CITY OF ALBUQUERQUE

July 27, 2018

RE: **Bosque Antigua
Gabaldon Dr NW
Grading and Drainage Plan
Engineer's Stamp Date 6/26/18
Hydrology File: G11D071**

SECTION B-B
NTS

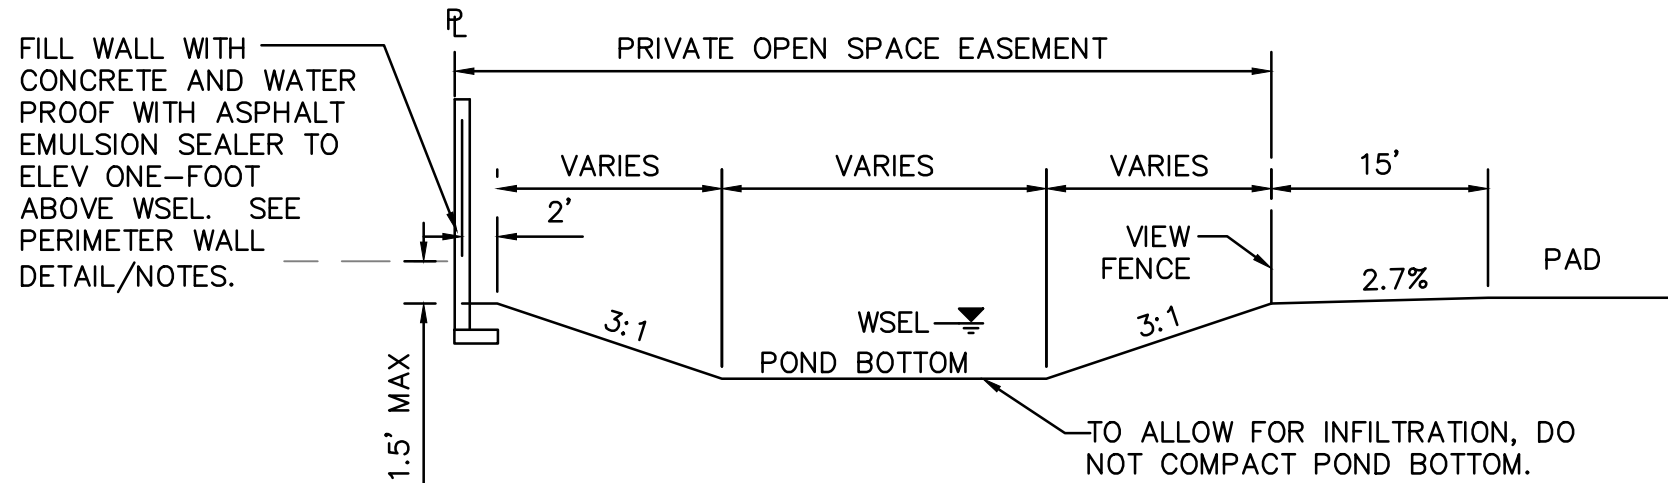
6. Section B-B shows a new garden wall on the property line. Either inset all new walls (and their footers) from the property lines or provide written and signed permission from the neighbor for the encroachment.
